Contact: Peter McManus  
Phone: 02 9228 6316  
Fax: 02 9228 6455  
Email: [peter.mcmanus@planning.nsw.gov.au](mailto:peter.mcmanus@planning.nsw.gov.au)  
Our ref: MP07\_0158 MOD 2

**Exhibition of Section 75W Modification Application for The University of Sydney  
Abercrombie Precinct Redevelopment, Darlington (MP07\_0158 MOD 2)**

Drawing Title: **PLAN CARPARK LEVEL**

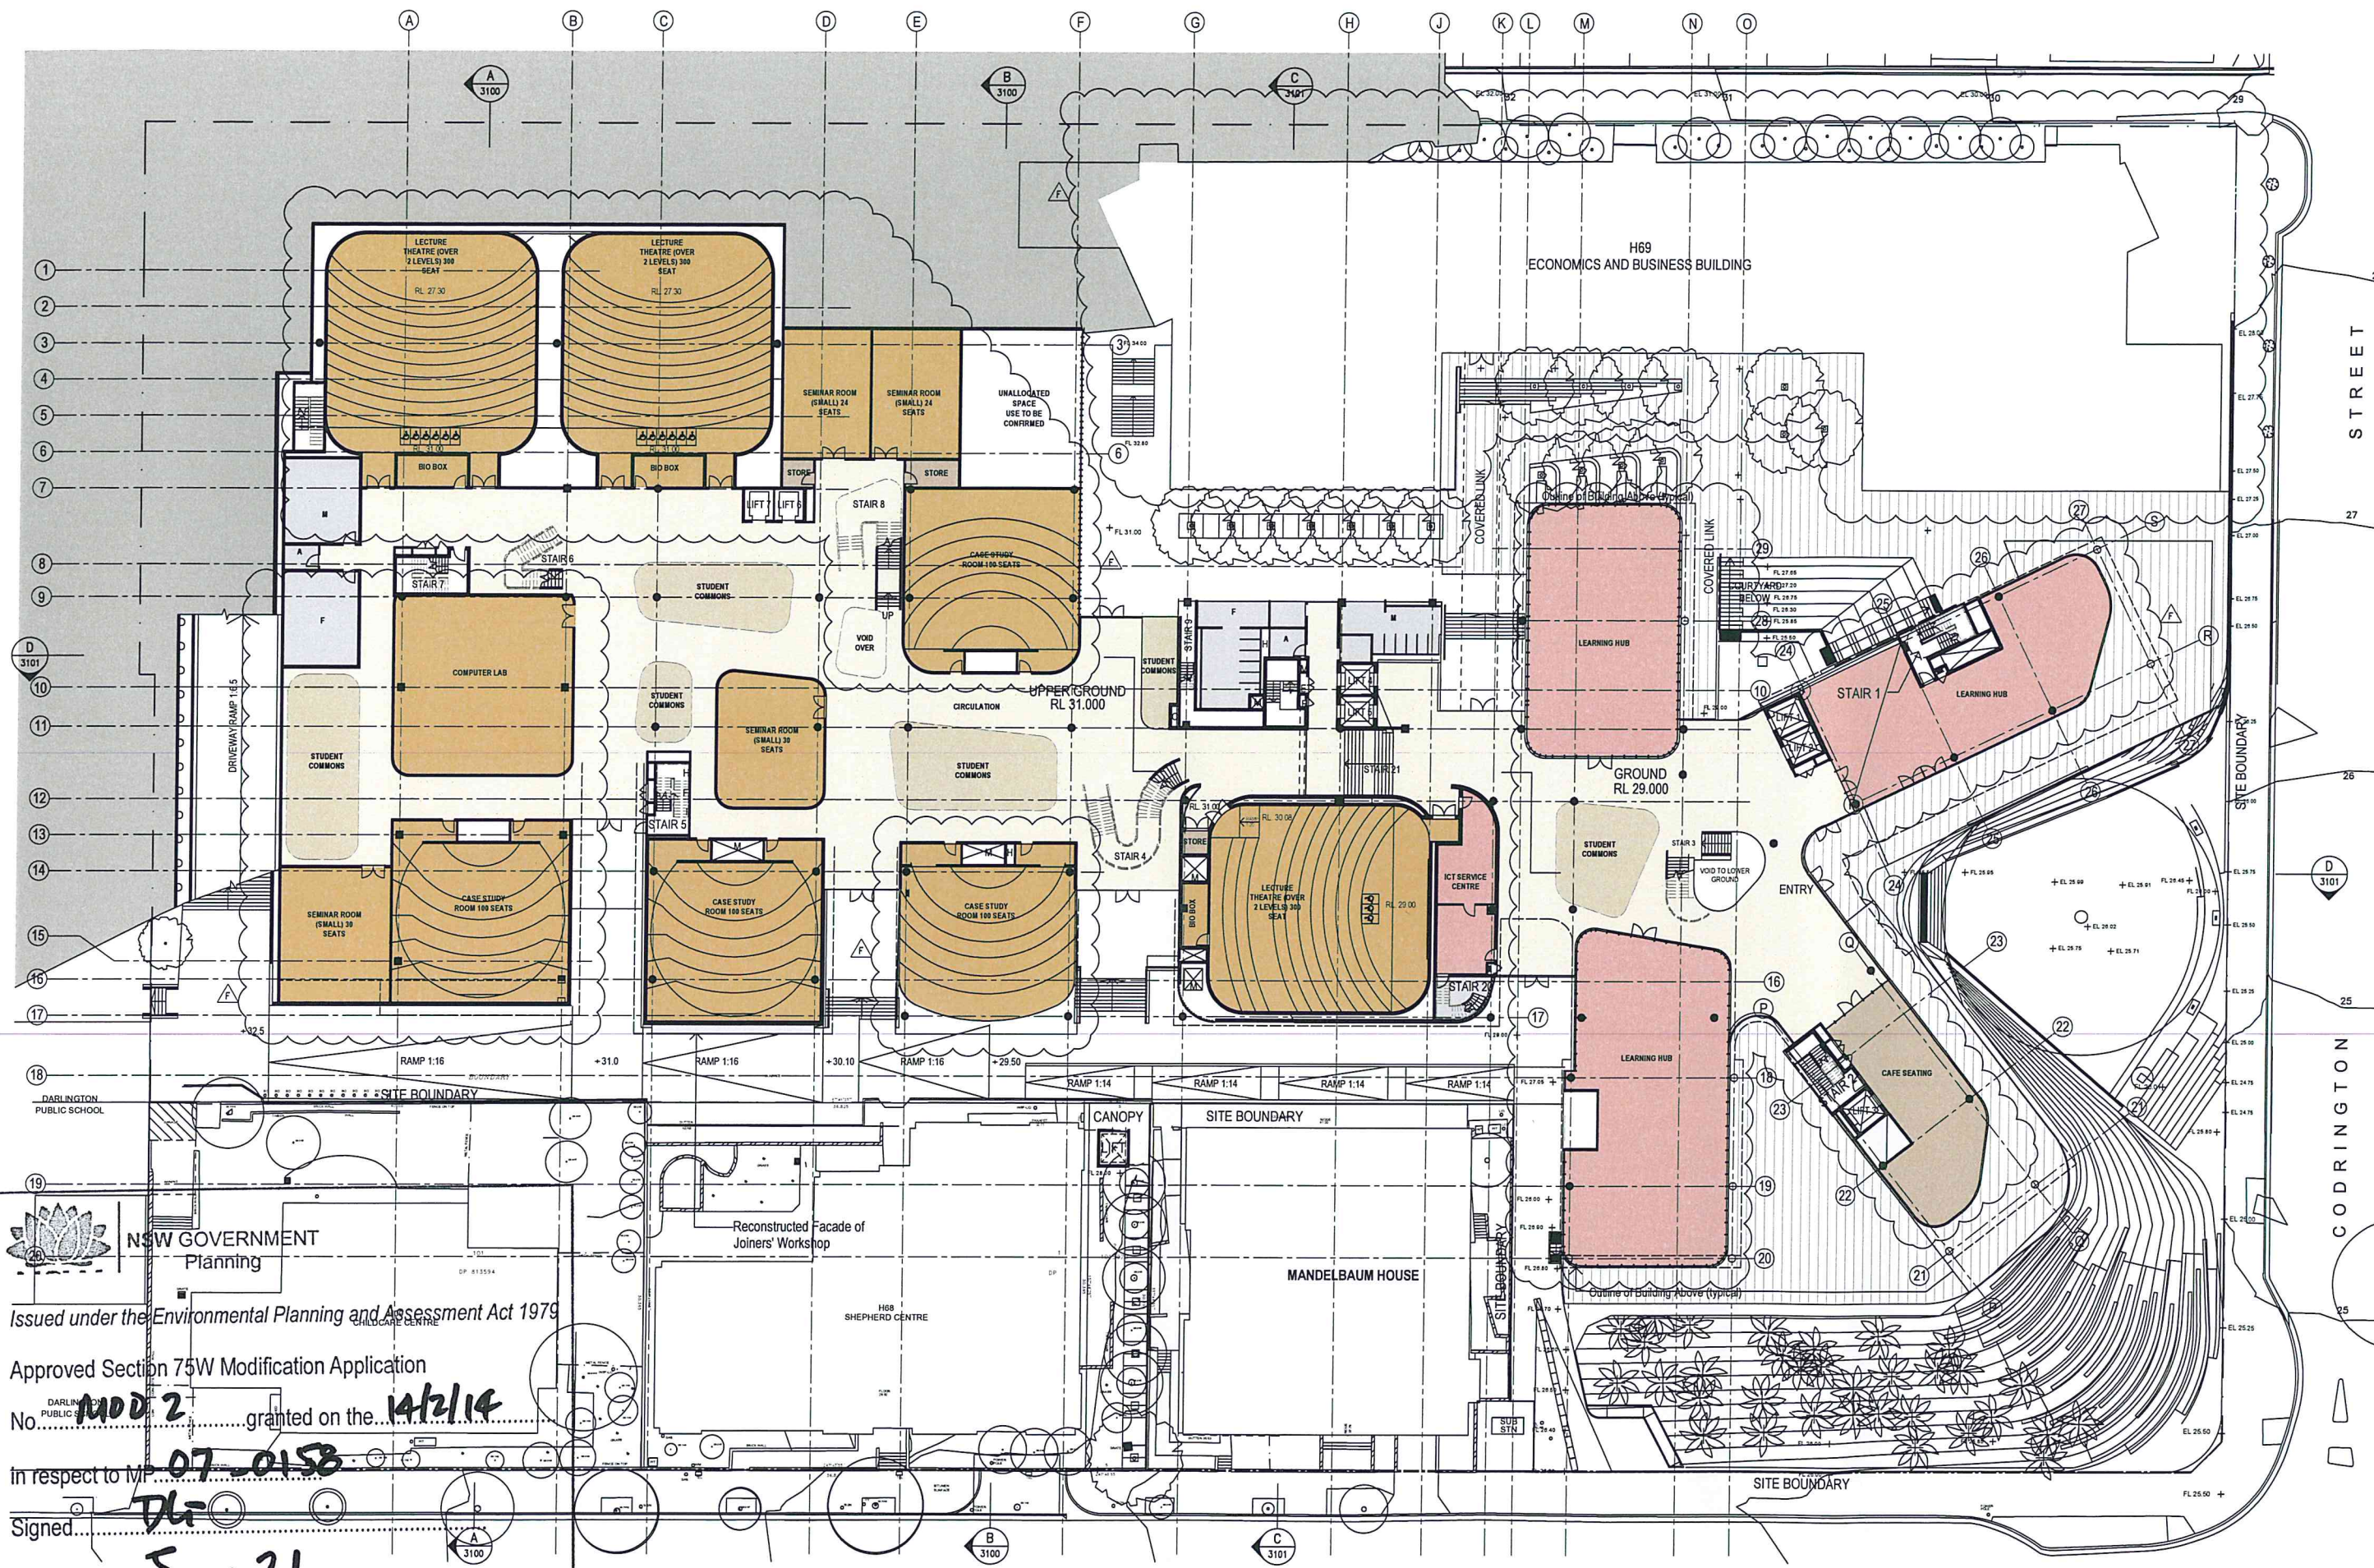
- Further to the concerns raised within the public submissions received, details are to be provided in relation to the proposed method and location of the basement car park ventilation system and any associated mitigation measures to control emissions.

## **Appendix D: DARLINGTON LANE PASSING BAY**

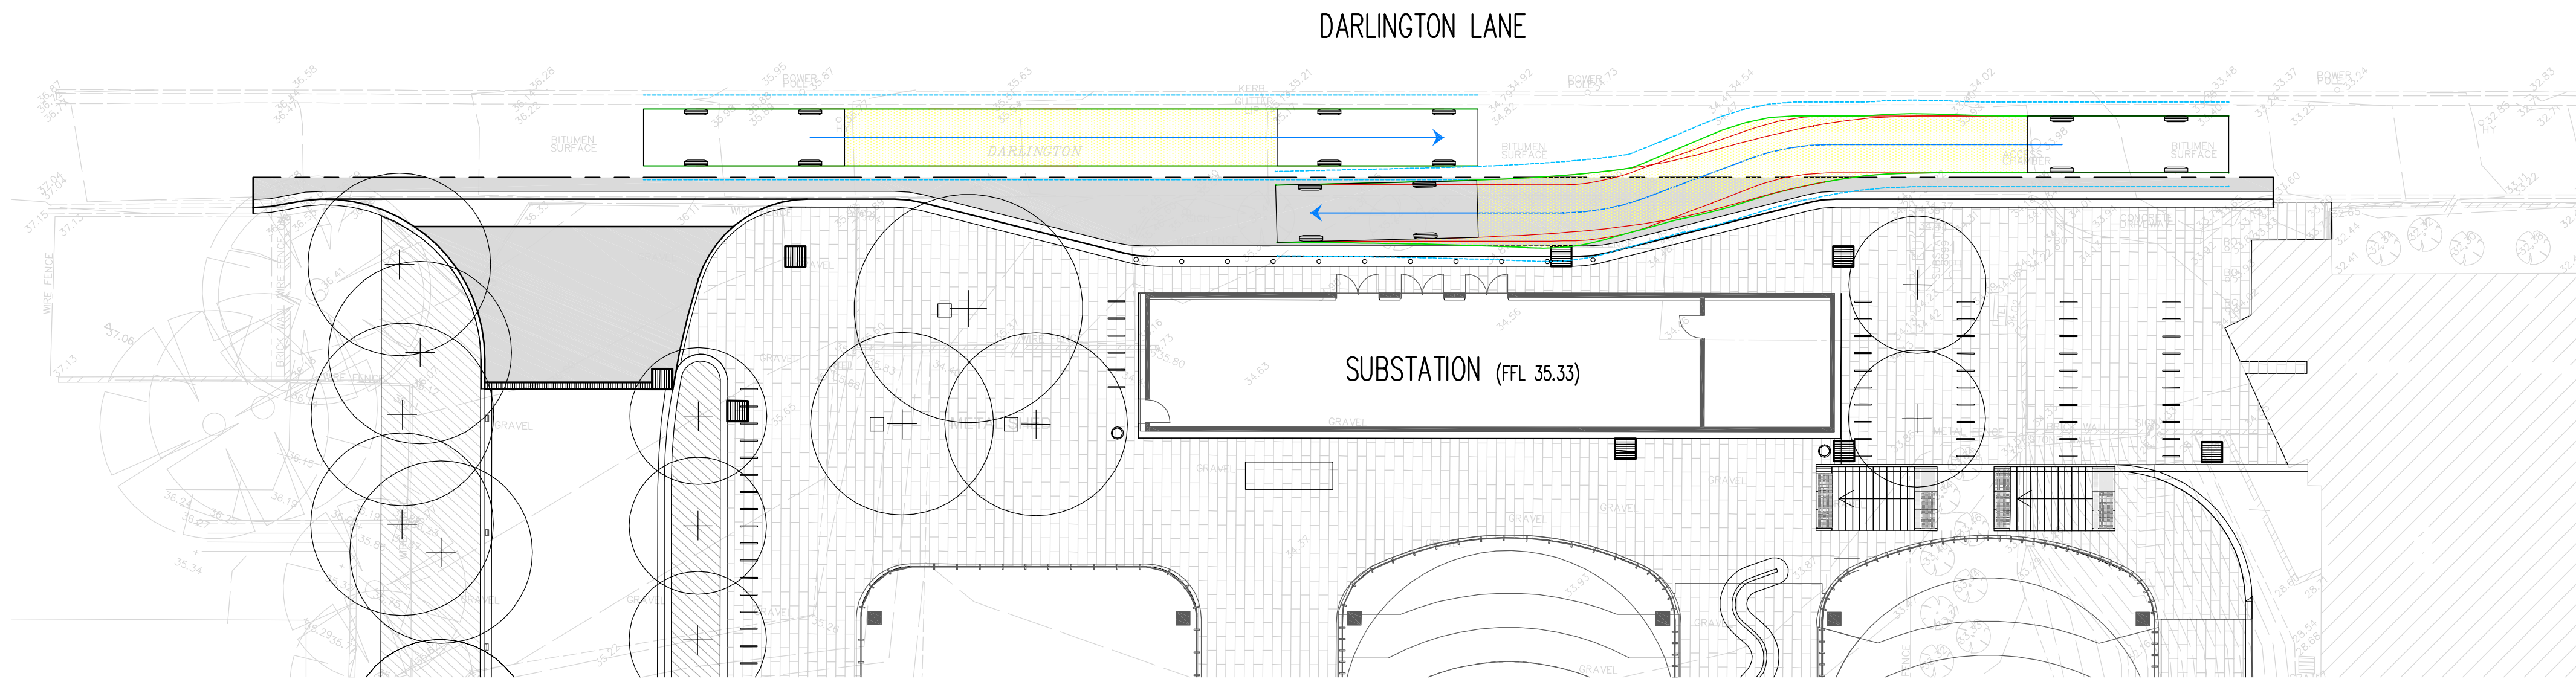
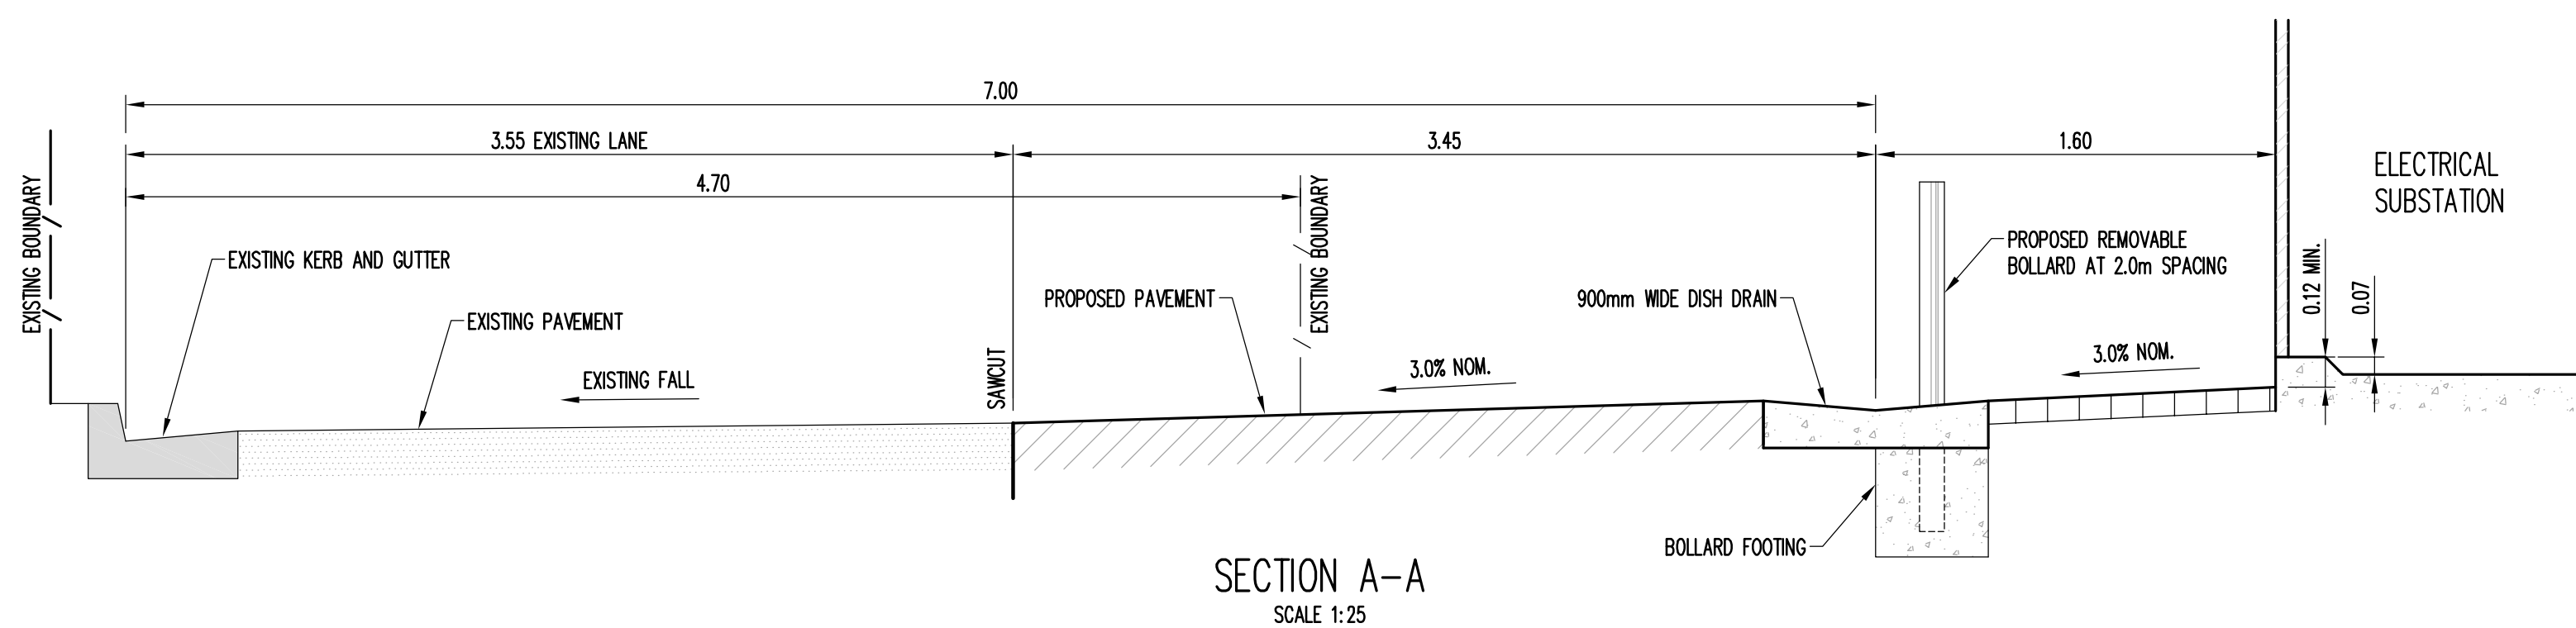
- Notwithstanding the comments provided by council in relation to the use of the space adjacent to the substation for the purposes of a temporary passing bay until such time as approval through council's local traffic committee establishes Darlington Lane as one-way, details are to be provided demonstrating the provision of soft landscaping along the Darlington Lane elevation of the substation to soften and screen its appearance within the streetscape.
